From: Amanda Scholes on behalf of Planning.Responses
Sent: 07 January 2019 11:32
To: Planning Scanning
Subject: FW: A18237C. Kings Beach Hotel (P/83/18/DOC)

Further drainage engineer advice

From: Laura Gibbons
Sent: 04 January 2019 13:44
To: 'Andy Johnson' <[redacted]>
Cc: 'Tom Hall' <[redacted]>, Simon Davis <[redacted]>
Subject: RE: A18237C. Kings Beach Hotel (P/83/18/DOC)

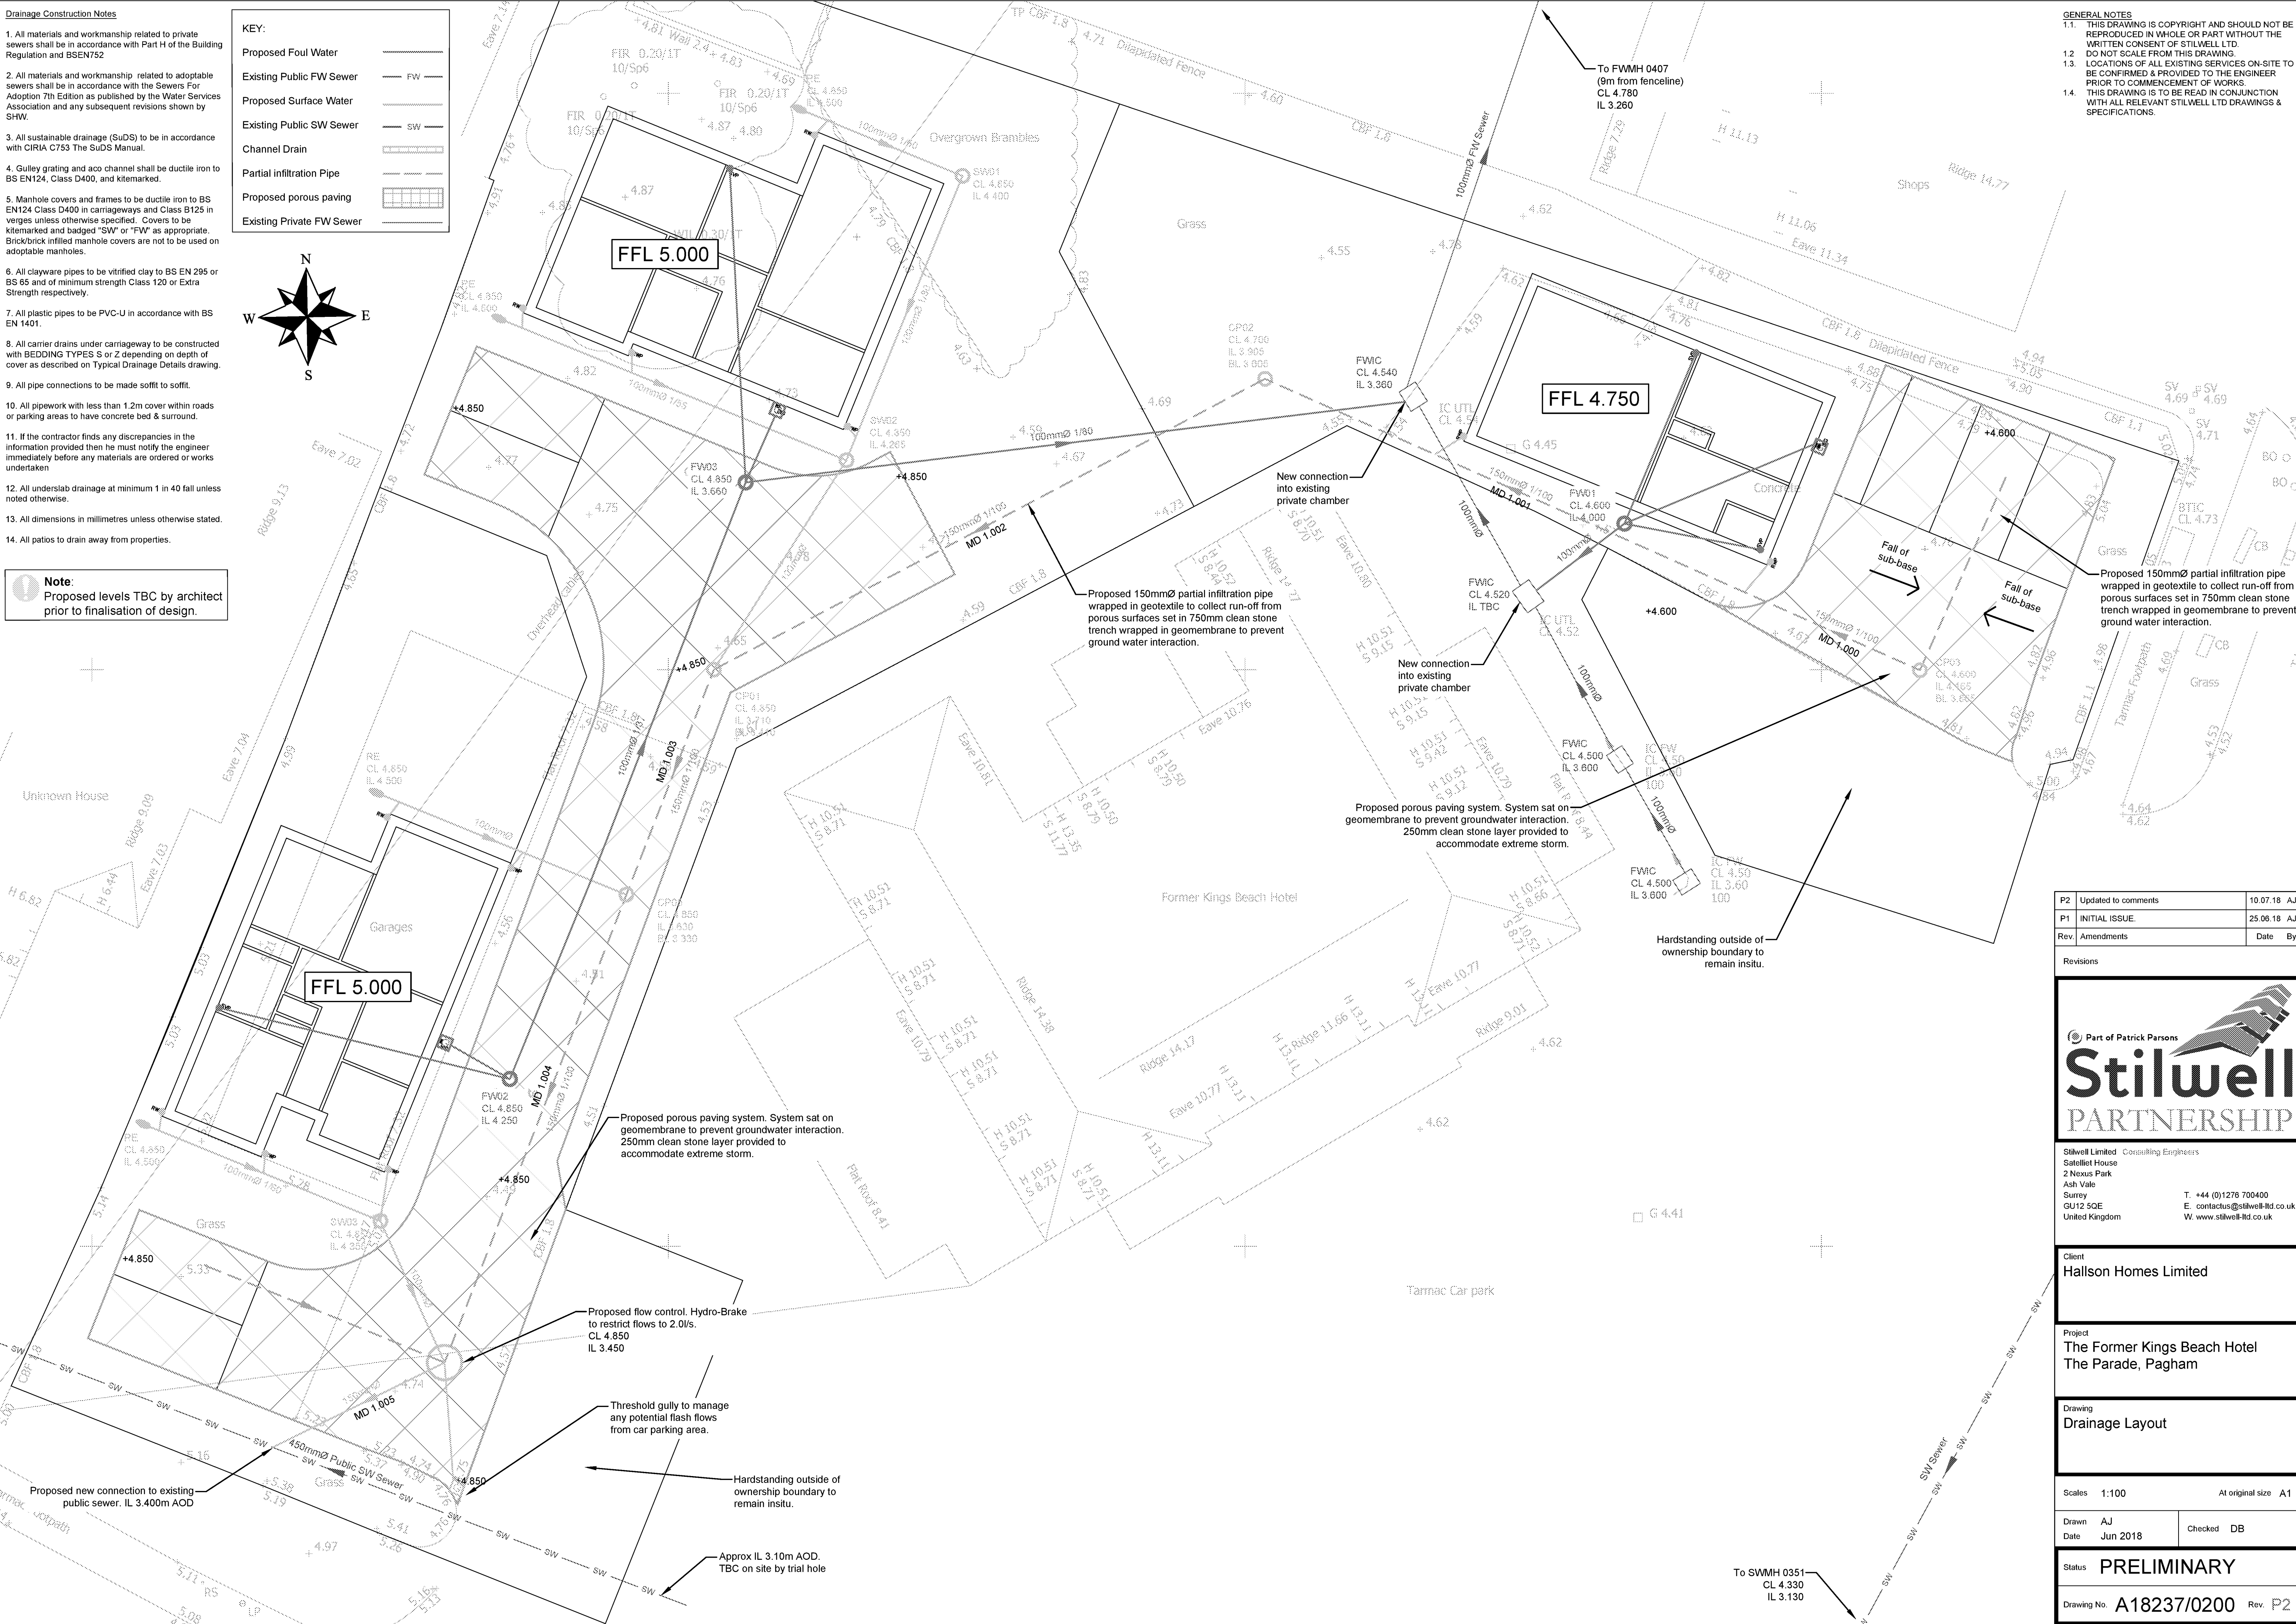
The drainage layout submitted doesn't show the permeable paving extents. I don't know if the layer was just switched off or what. However, please ensure extents are shown and that the paving is labelled up with finish and formation level.

The calculations also demonstrate that 390mm stone is required in the west, and 460mm in the east. Please update drawings accordingly.
